2403011 Berrima Gaol

28th May 2026

Berrima Quarter Redevelopment – Landscape Design Letter
Blue Sox

Tree Canopy Study

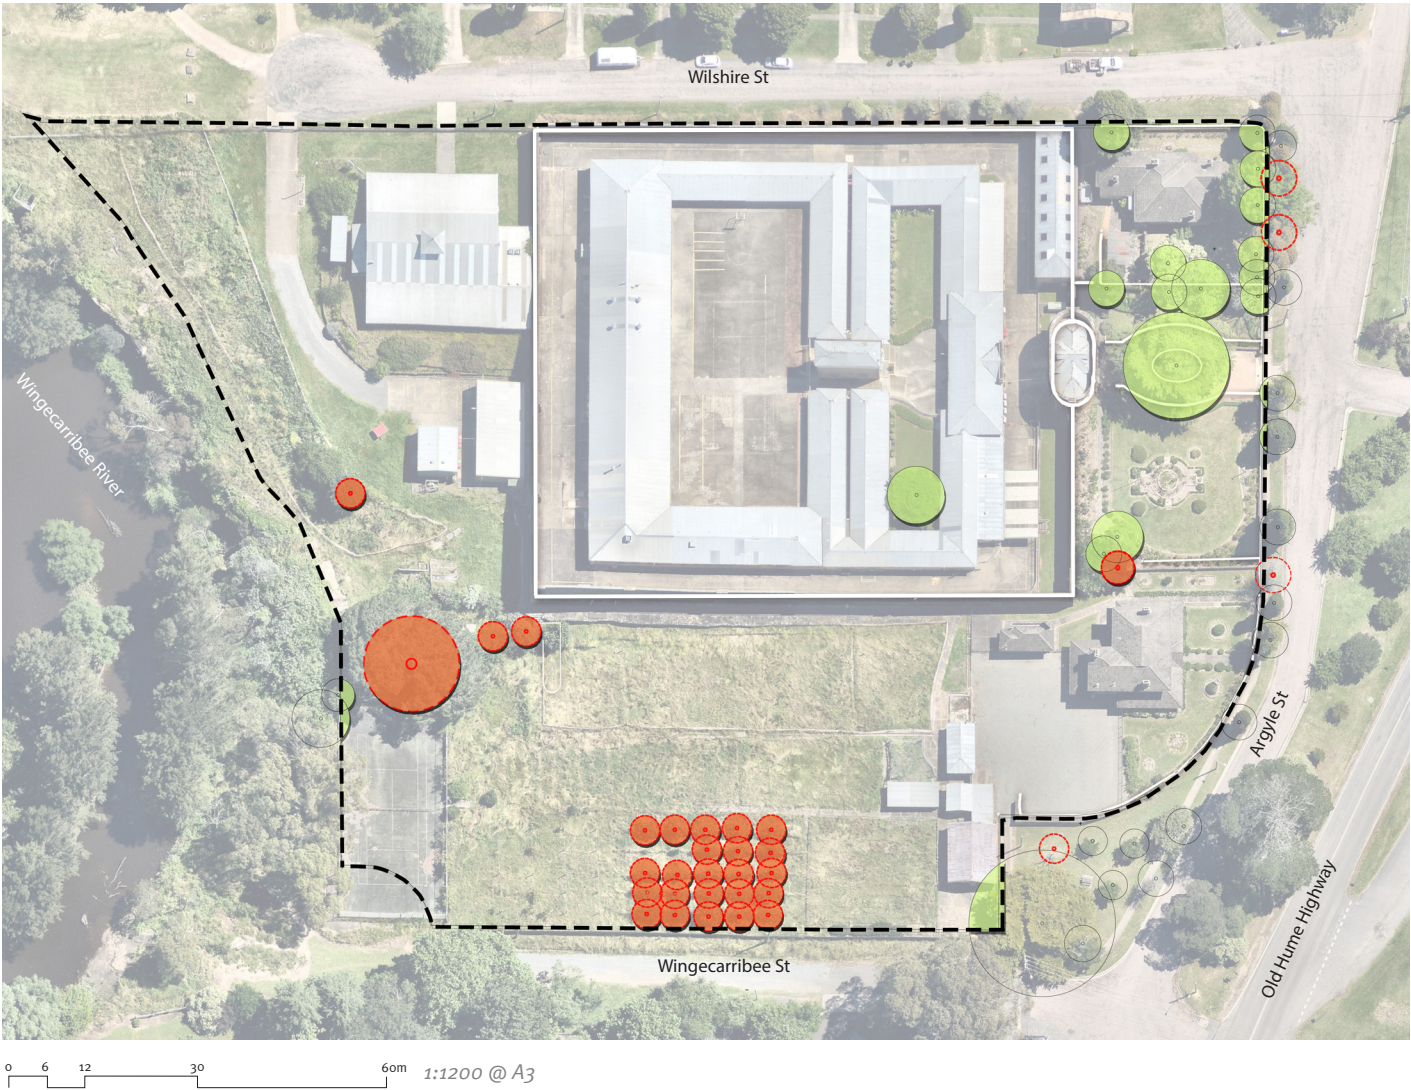
- *The Architectural Design Report (Appendix 6) identifies that the project will achieve a net increase in tree canopy cover compared with existing site conditions. Council welcomes this commitment but requests that the extent of tree canopy increase be quantified*

Page 2 of the Addendum Landscape Architecture Report outlines the existing canopy coverage on the site and the proposed canopy coverage for the project being a net increase of 8.2% .

Swale and Car Park Buffer Planting Along Wingecarribee St

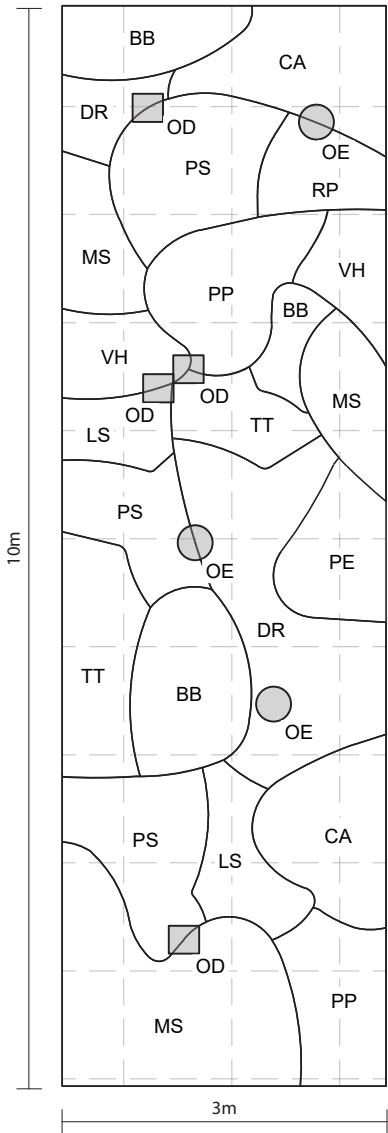
- *Incorporate dense landscaping and canopy planting to soften the carpark interface*
- *Use locally characteristic materials (sandstone edging, timber fencing) to integrate new elements visually with the surrounding village fabric*

Page 9 of the SSDA Landscape Architectural Report notes the proposal for mass planting beds and tree planting between sections of the parking bays and along Wingecarribee Street edge, with the intent to soften the carpark interface. Page 4 of the Addendum Landscape Architecture Report provides an indicative planting bed layout showing plant species, density and numbers for the embankment between the car park and Wingecarribee St.

Arbor

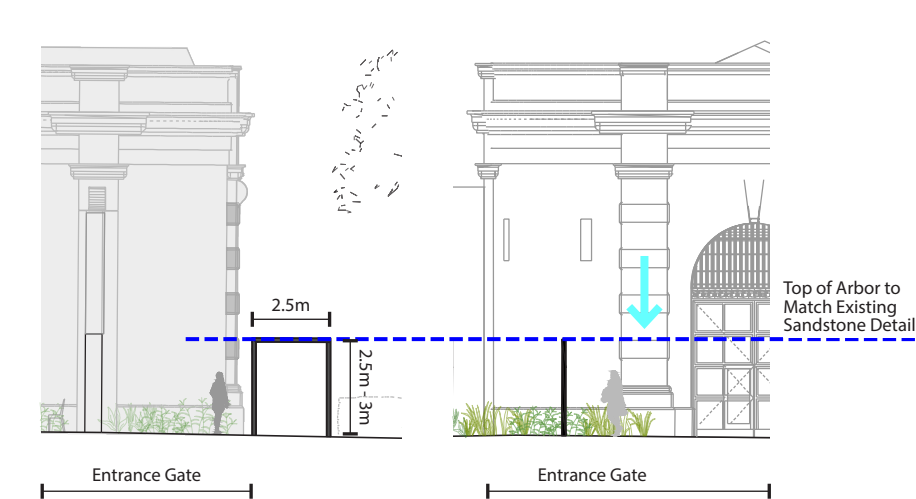
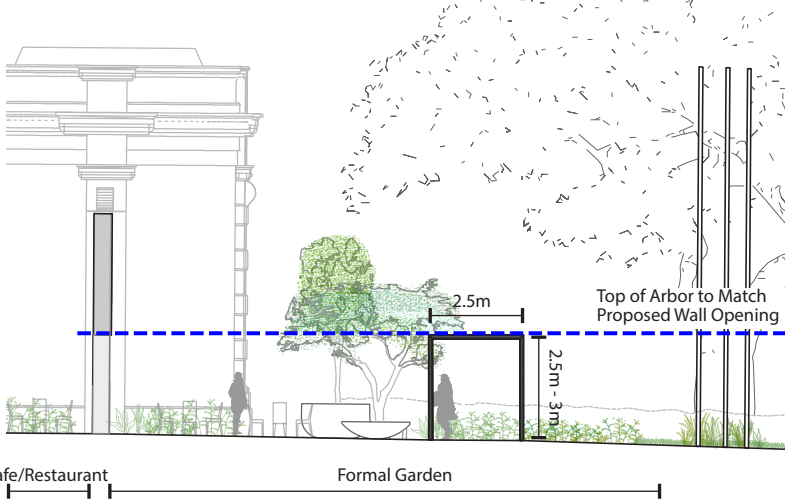
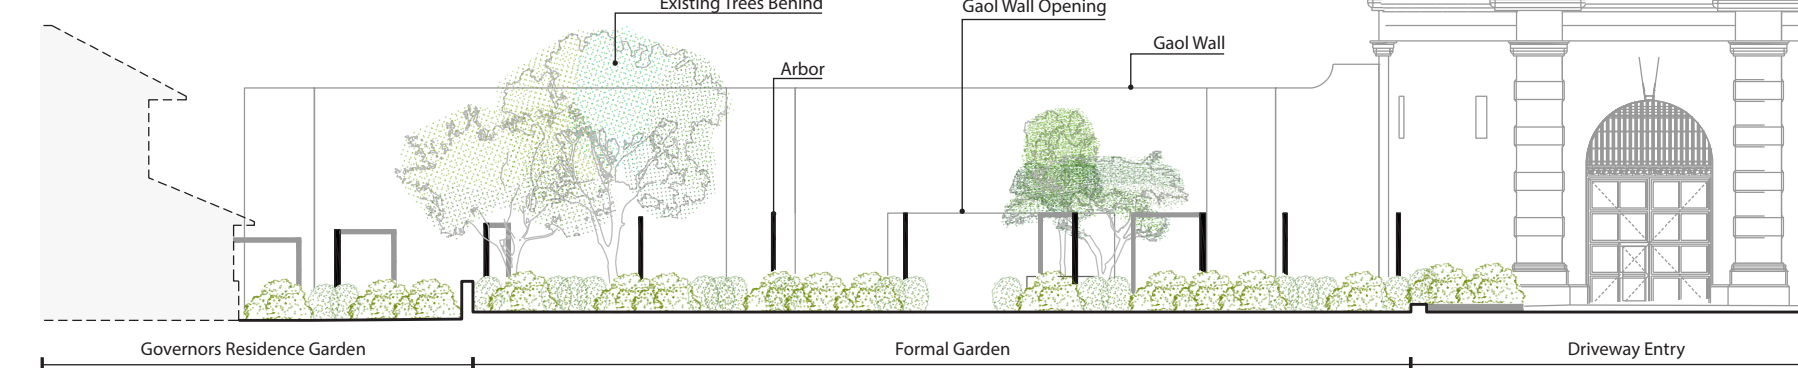
- *The landscape drawings show an arbor is proposed to be erected within the gaol's front garden close to the proposed new opening in the gaol wall. Please provide additional details of the arbor to illustrate its design and its visual permeability, noting that the new opening in the gaol wall is intended to increase permeability into the site. Please assess the heritage impacts of the proposed arbor*

Page 5 of the Addendum Landscape Architecture Report outlines high-level design intent, design parameters, materiality and precedent imagery. Indicative dimensions as well as section details have been included to provide site context.

Glasshouse Within The Landscape

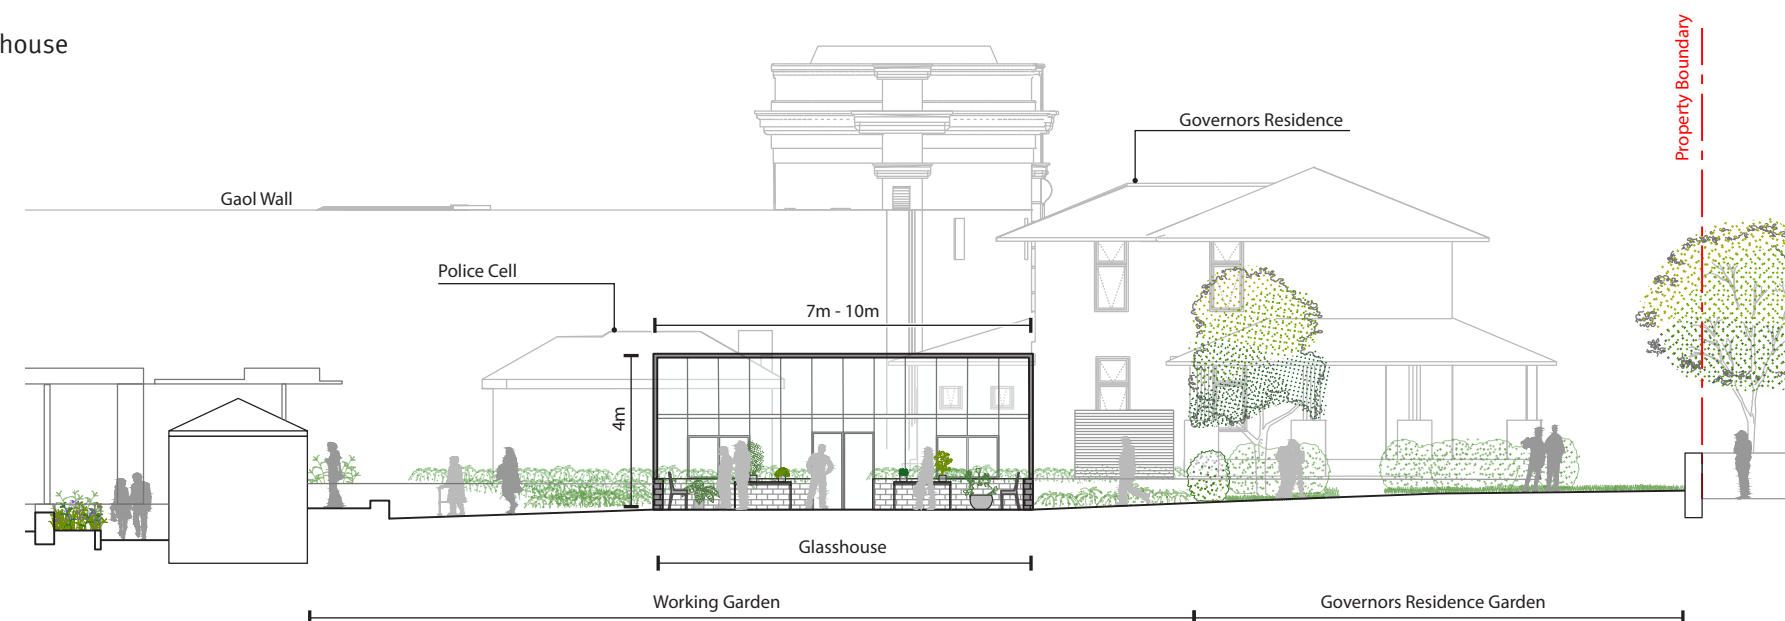
- *The glass house will be a new structure outside of the gaol walls. Please provide additional details of the proposed glasshouse and its scale in relation to existing adjacent structures. Please assess the heritage impact of the glasshouse*

Page 6 of the Addendum Landscape Architecture Report outlines high-level design intent, design parameters, materiality and precedent imagery. Indicative dimensions as well as section details have been included to provide site context.

Intersection Design Strategy

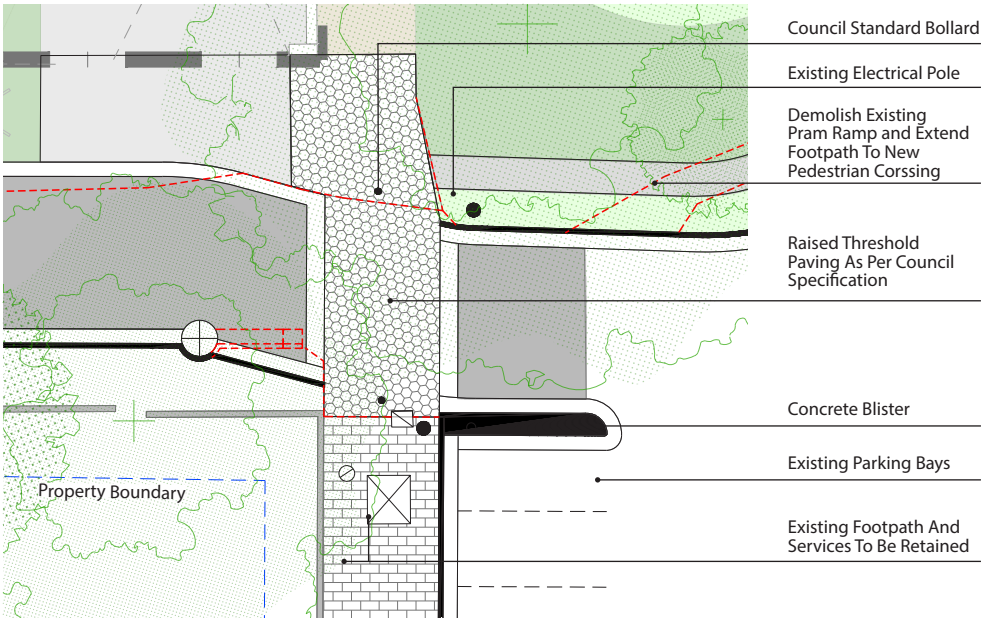
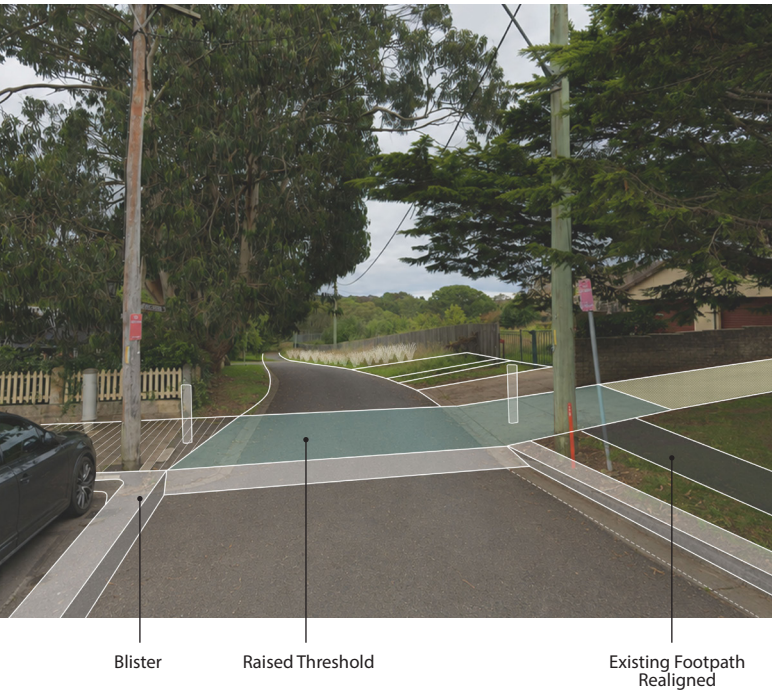
- *Pedestrian connectivity between the Berrima Gaol site and the adjoining Surveyor General Inn should be clearly addressed to ensure safe and coordinated movement between these two activity nodes, minimising potential conflict between pedestrians and vehicles*

Page 7 of the Addendum Landscape Architecture Report outlines the design intent for pedestrian movement and vehicular access at the intersection of Wingecarribee Street and Argyle Street. The proposal shows minor demolition works to the

existing kerb and pram ramps to formalise the pedestrian crossing and improve sight lines. Any proposal would need confirmation of swept paths and support from Council Traffic Committee.
